Application number: 2019/91980	
What is the application for?:	Erection of two storey side extension, front porch and formation of new vehicula
Address of the site or building:	6, Osborne Terrace, Batley, WF17 0LZ
Postcode:	WF17 5NN

User comments

NORTH ELEVATION

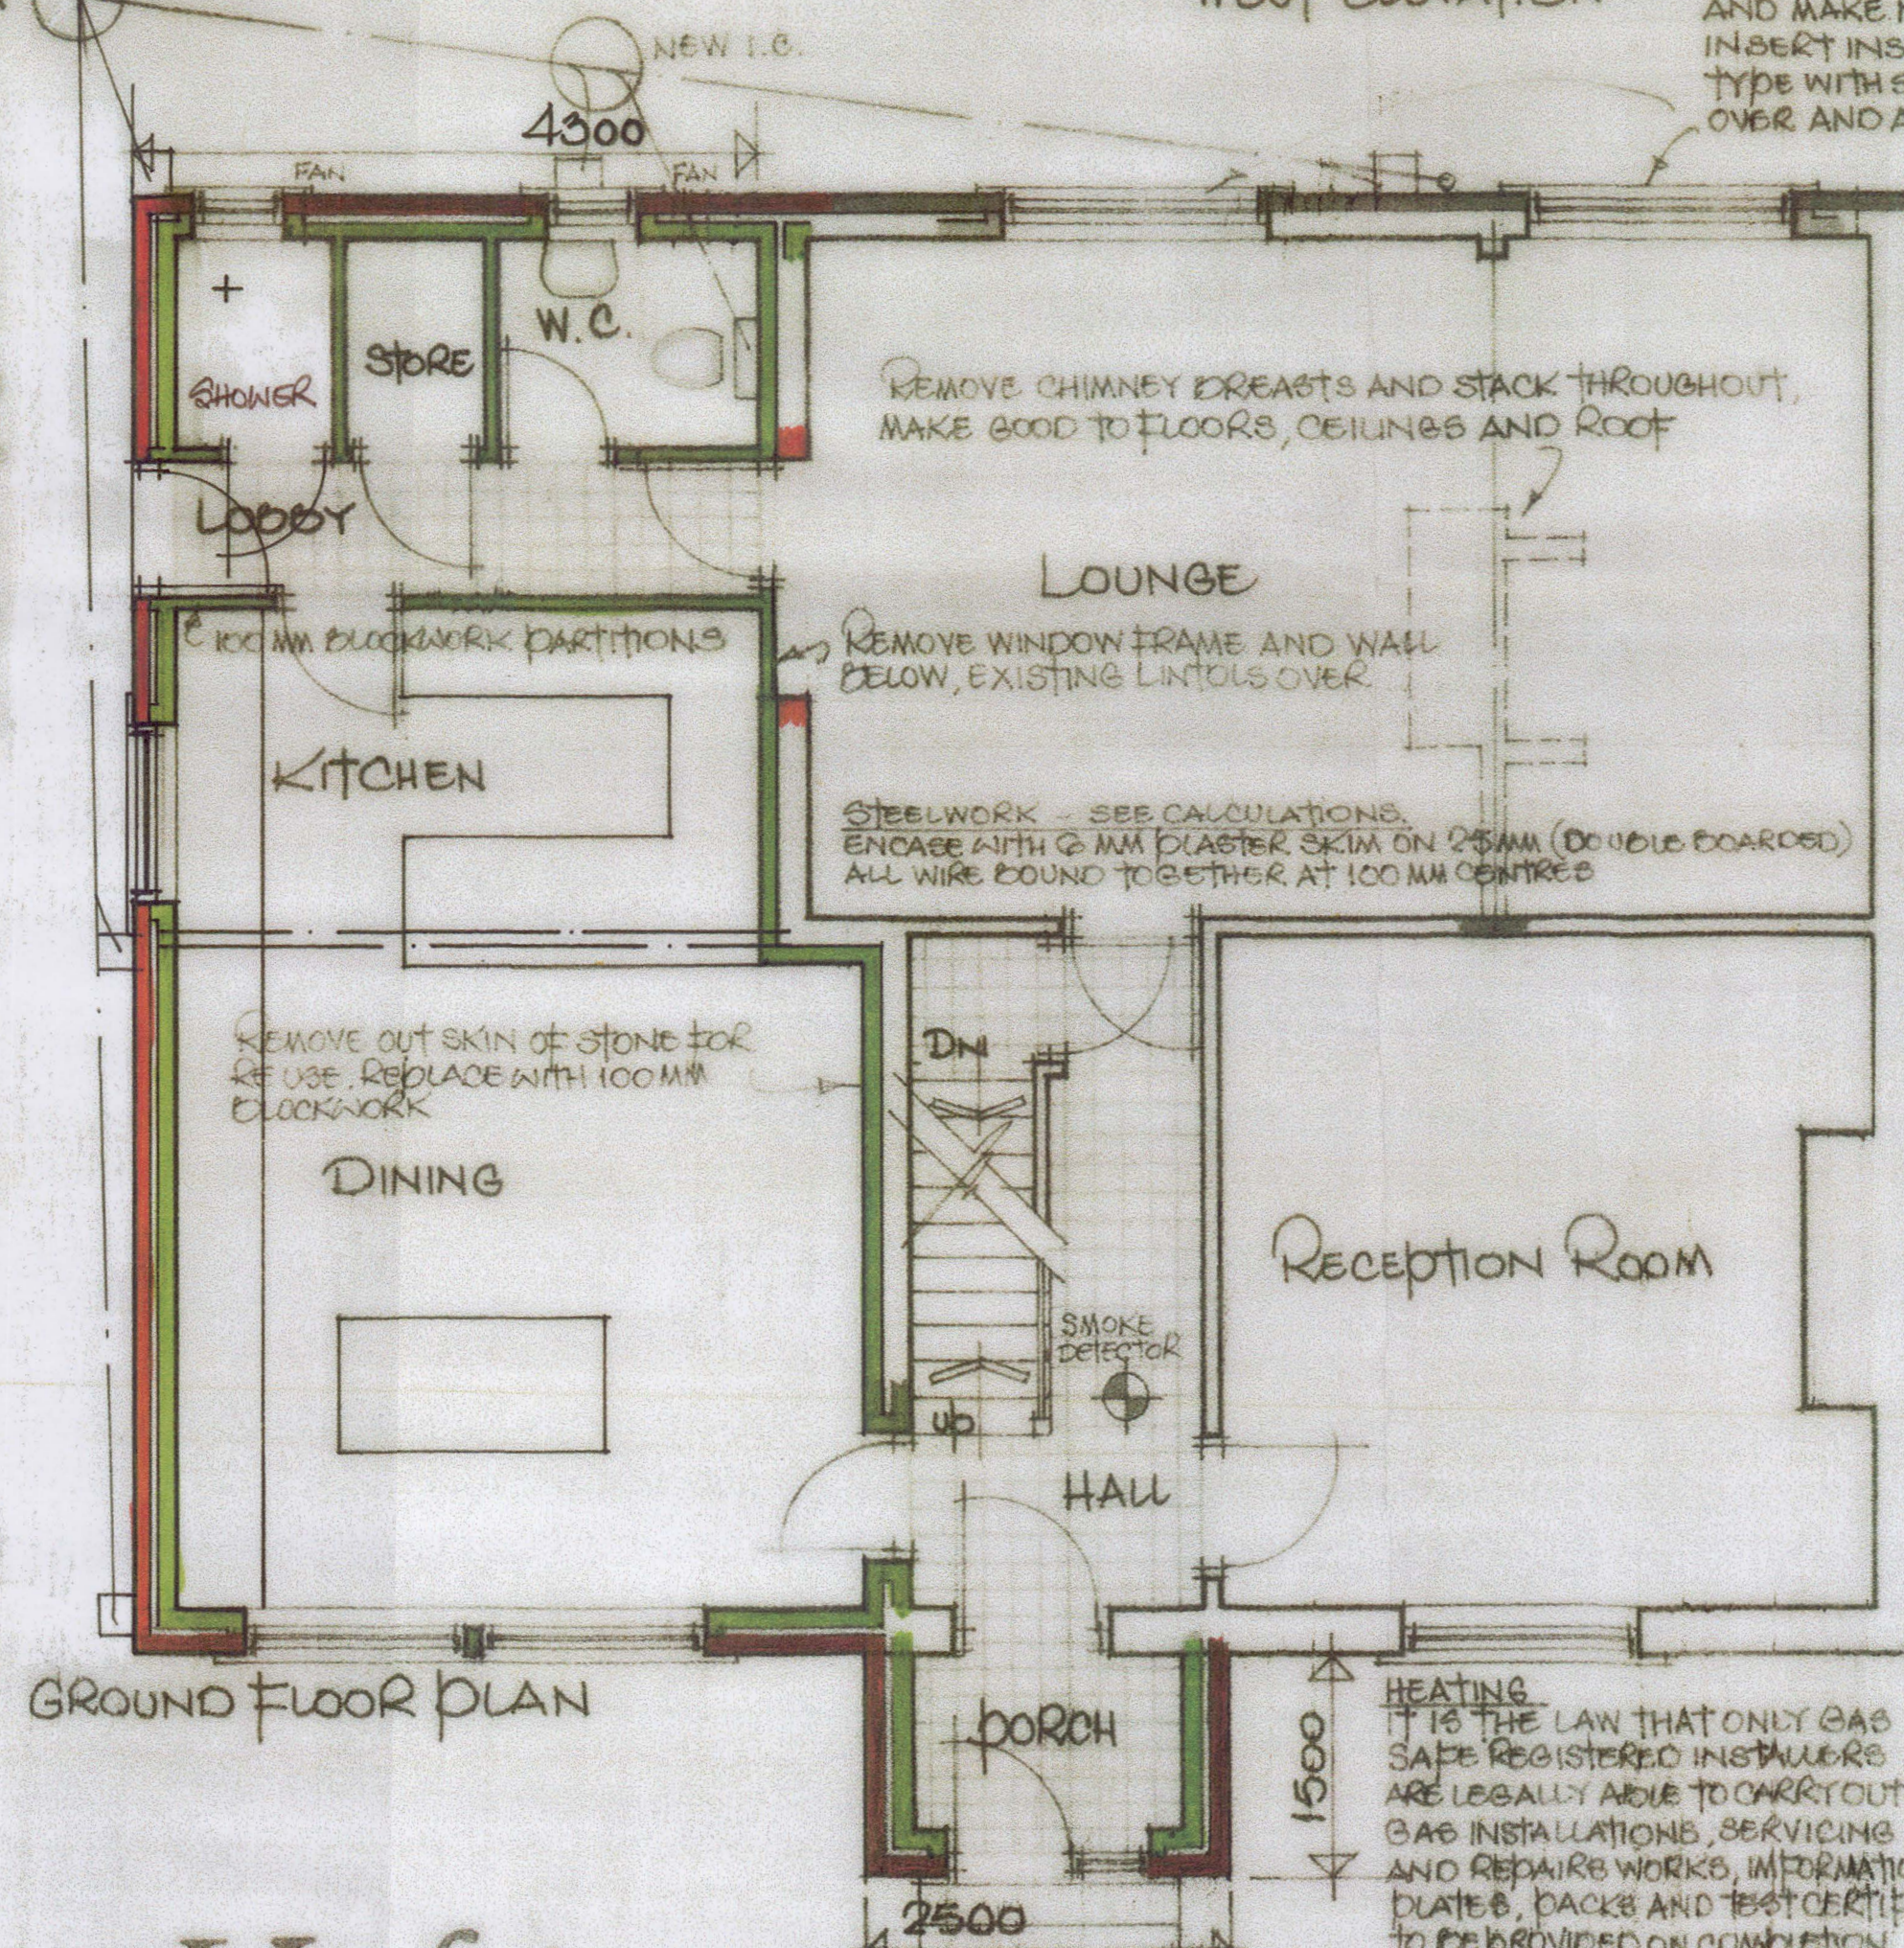
Type of comment: An objection
I would like to object this planning application due to several concerns. Given the elevated ground level that the house occupies and the addition of a side extension, the house will become very imposing and will not be in-keeping with the rest of the street scene within this conversation area. The new additional bedroom will still have a window directly looking into the properties opposite, again given the elevated position of the property this window will not only be able to see directly into both bedrooms at the front of the properties but will have direct line of sight across the landings and into the bathroom at the rear of the rear of the property. There will be no privacy in the properties opposite. I am not objecting to the extension of the property but believe it could still be designed in a way that affects the local amenity less, is visually more acceptable with less impact on the street scene. I do, however, object to the introduction of access from Wayne Close as this will still encourage parking on Wayne Close to access the property which only exacerbates the parking issues particularly during school drop-off and pick up.
